Our Ref: GMC:LY:37315

17 April 2026

**Letter of Objection to proposed State Significant Development
Property: 65 Muston Street, Mosman (SSD-98068713)**

- Site
- Spit Junction Town Centre
- Indicative LMR Housing Area
- Route: <400m to Site

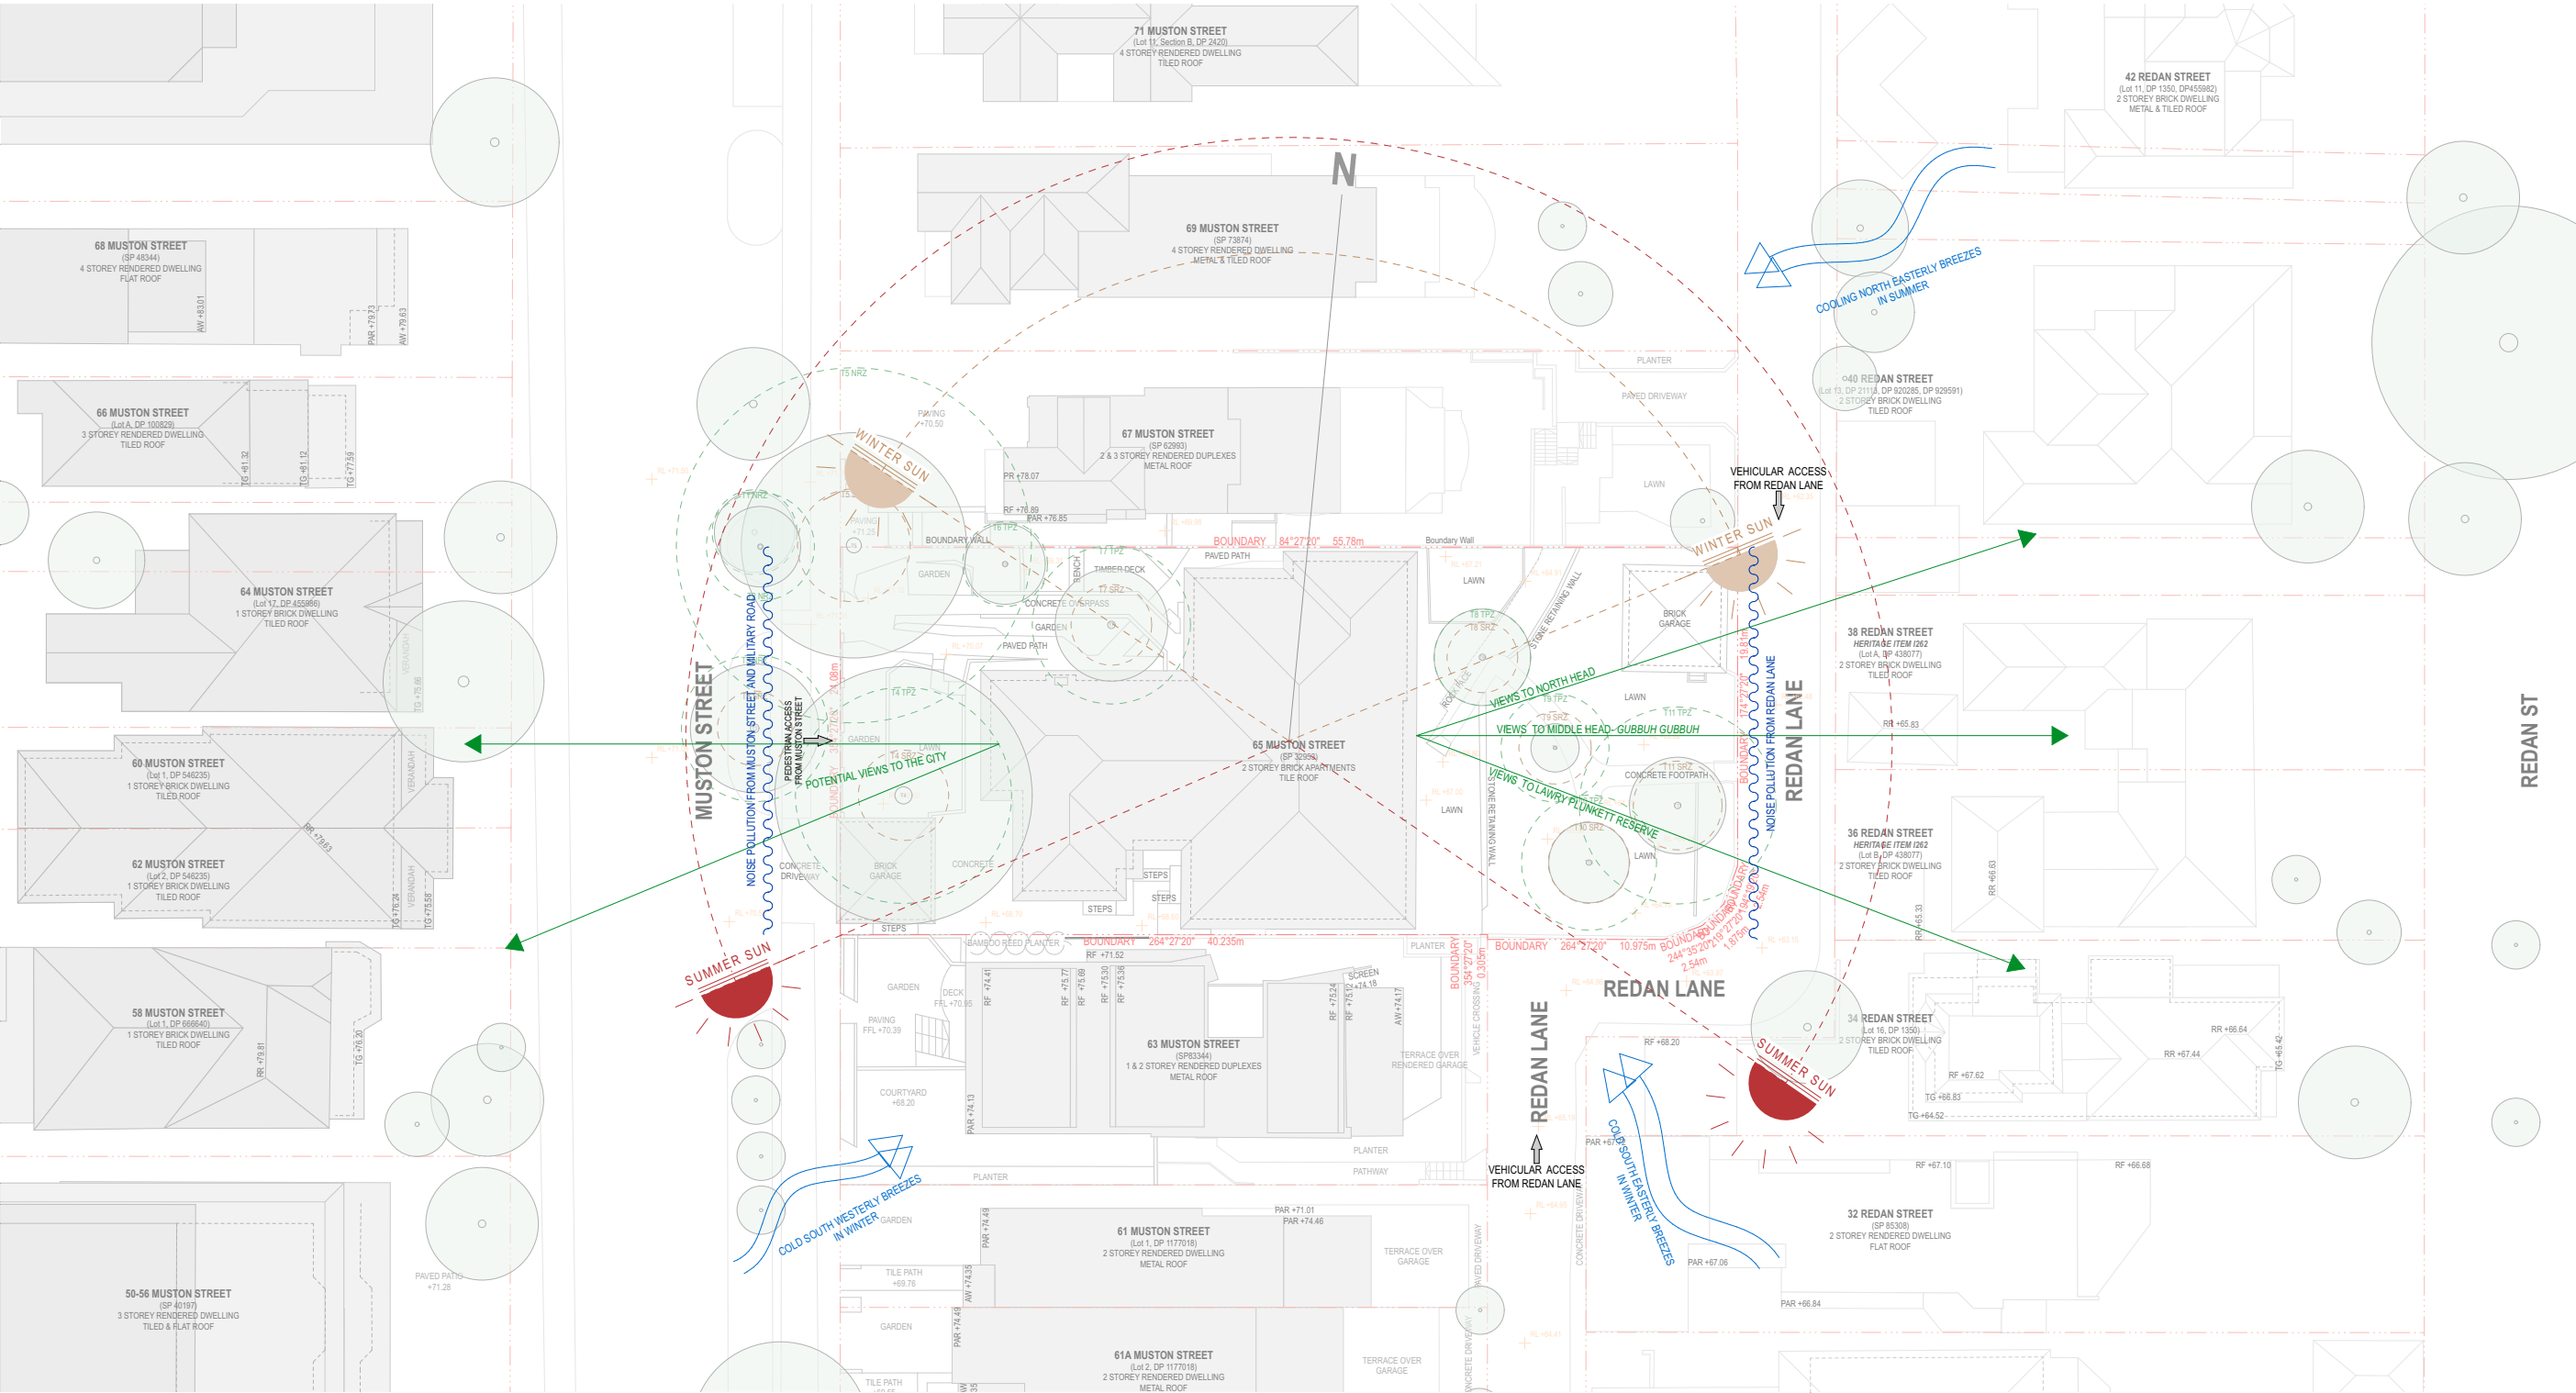
The application is supported by a Surveyors Report and accompanying ‘Plan showing route of pedestrian travel distance from 65 Muston Street’. The walking route to the South-East corner of the ‘Spit Junction Town Centre’ shows the subject site to be within 400m walking distance to the Town Centre, however the accompanying report does not confirmed this is via a safe and accessible route.

The distance to the site from the Town Centre is required to be verified to have been correctly applied in line with the legislative requirements outlined in the State Environmental Planning Policy.

The walking distance along a safe path identified by Survey provided in support of this submission is 418.3m.

The consequence of this measurement is significant given the legislation specifies applicable floor space ratio based on the sites distance to the Town Centre. From our assessment, the site is located in an outer area, being within 400m- 800mm safe walking distance.

Shadow Diagrams - Maximum Building Height + Bonus (28.6m)

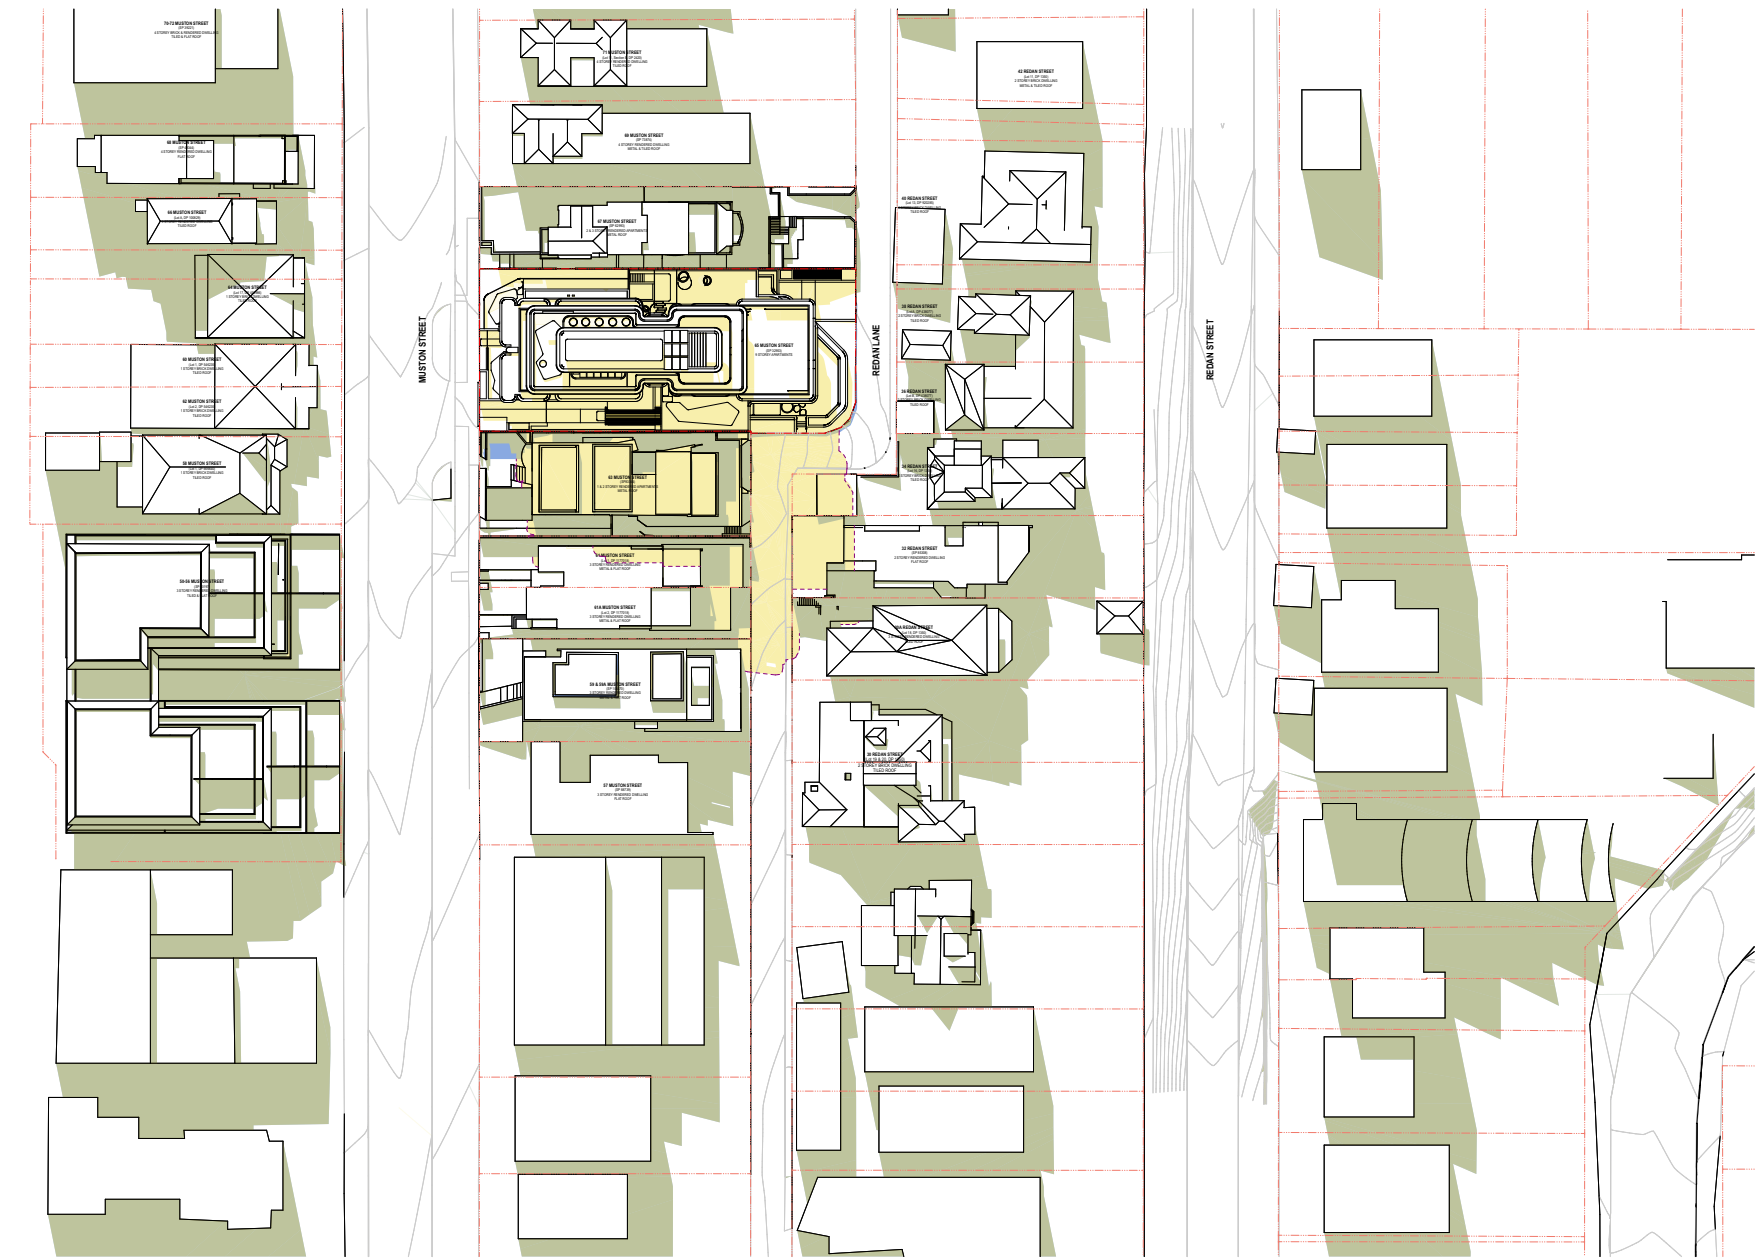
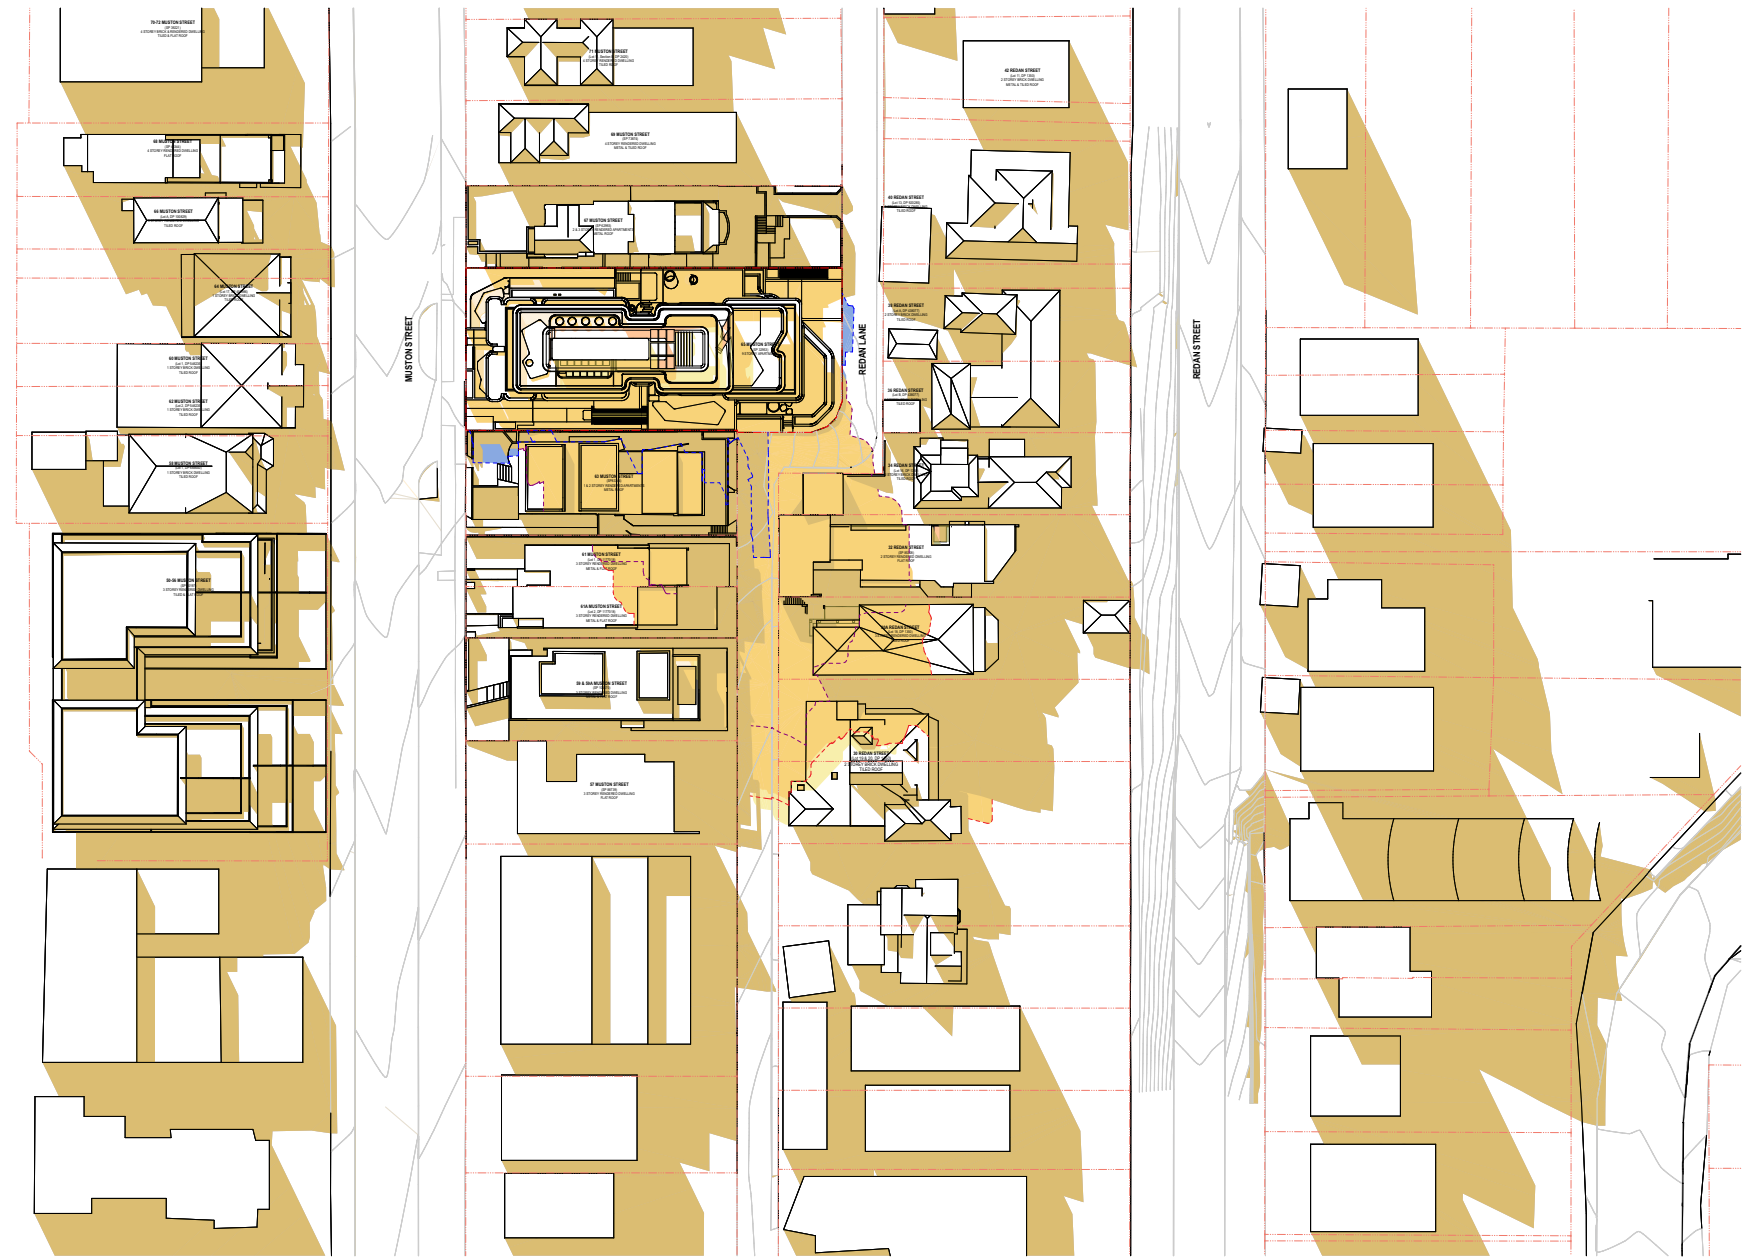
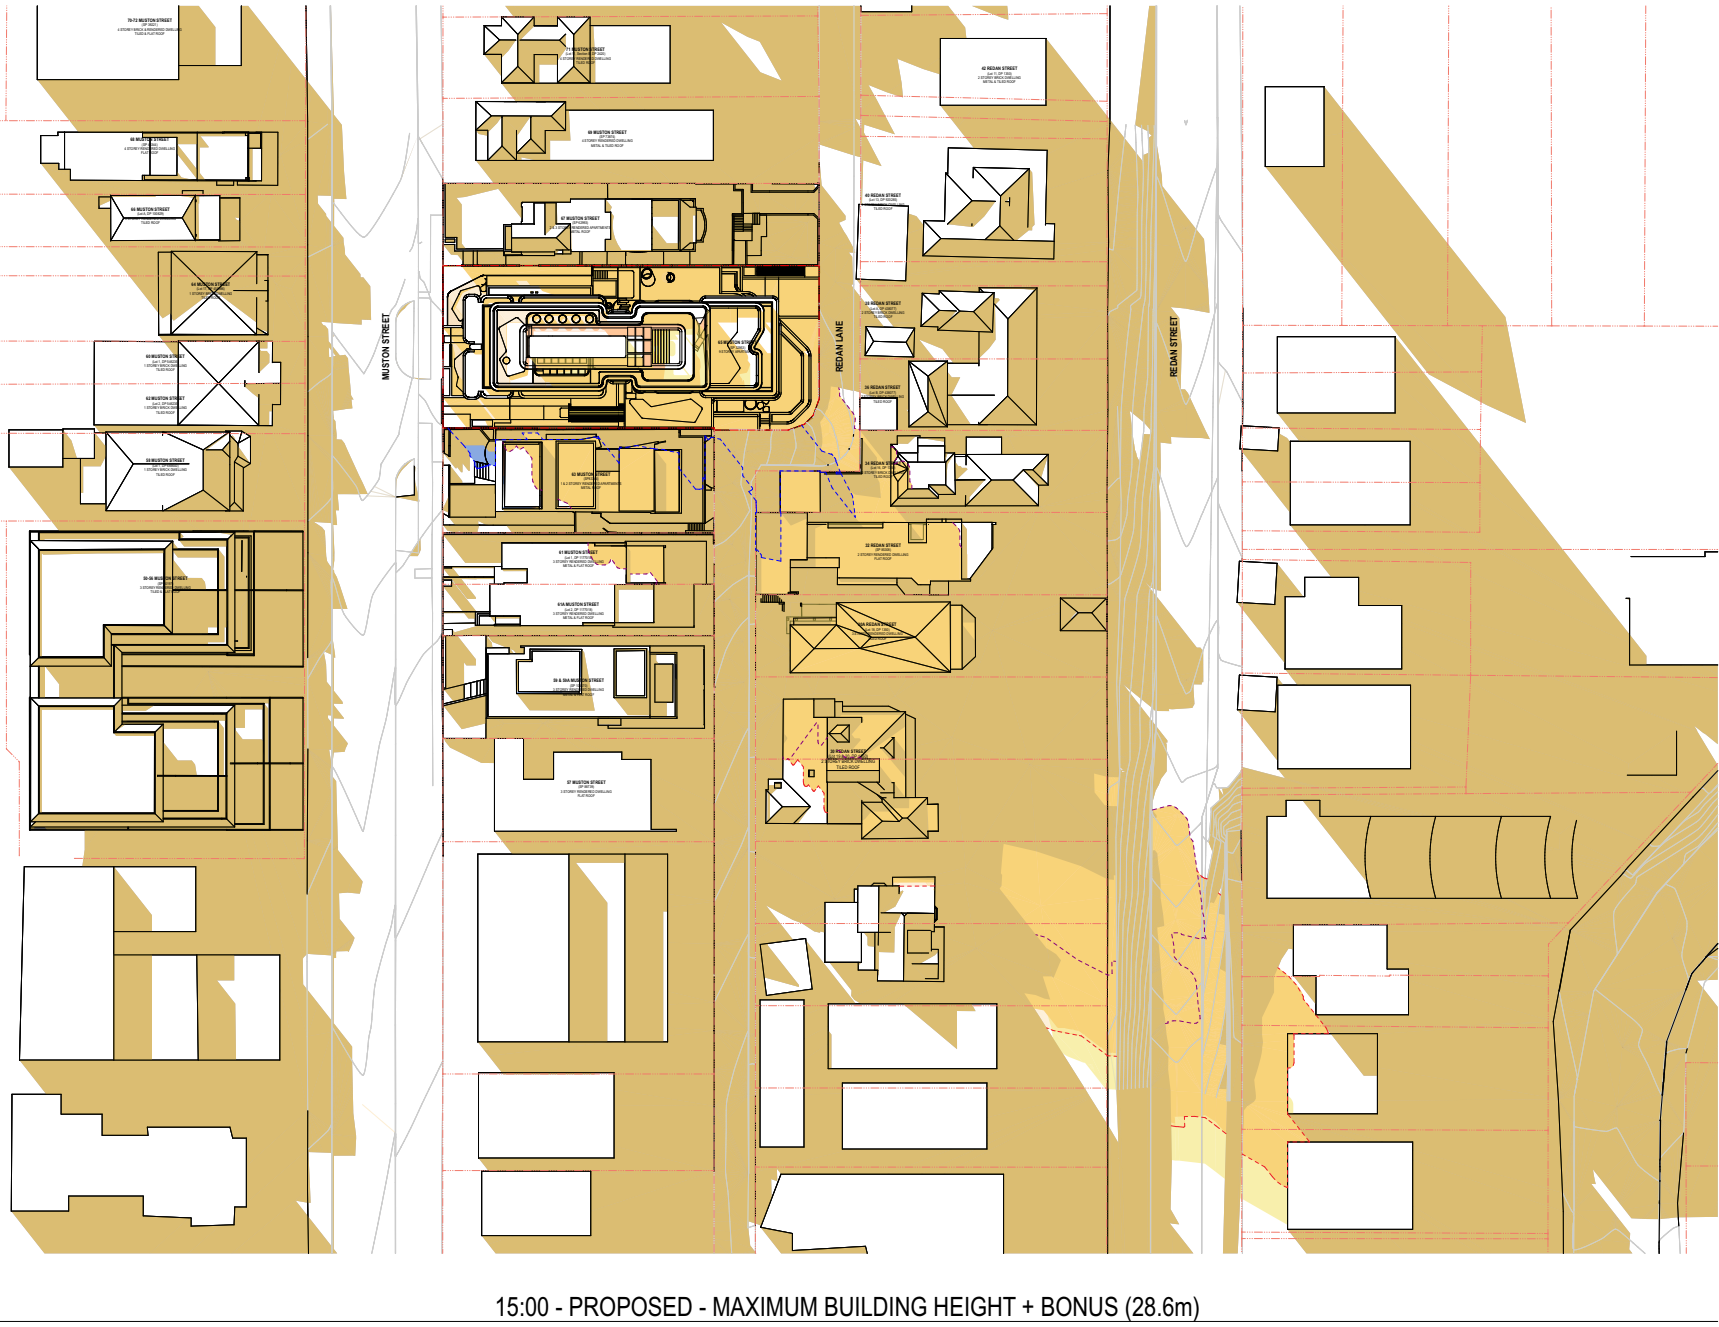
The shadow diagrams confirm the extent of solar access reduction. This is significant to the adjoining owners to the south, for every hour shown on the plans, for a development to either 22m or 28m in height.

The impact of the built form to 28.6m is shown below for the winter solstice when sunlight is most needed.

Our client currently enjoys solar access for all hours of the day, including to a north facing courtyard. The loss of amenity this proposal will result in is immeasurable should this building proceed.

The application relies on compliance with the LMR height and FSR provisions and broader planning framework to justify the significant breach. Notably, the planning control P6 under Part 5.8 of the MDCP foreshadows that east-west orientated lots may require increased side setbacks to facilitate appropriate solar access. The proposal has only provided the minimum setbacks and has not been amended in response to these impacts being identified.

The proposed reduction in solar access is not appropriate, in direct contravention of well established and fundamental planning controls and devastating to the amenity of impacted residents.
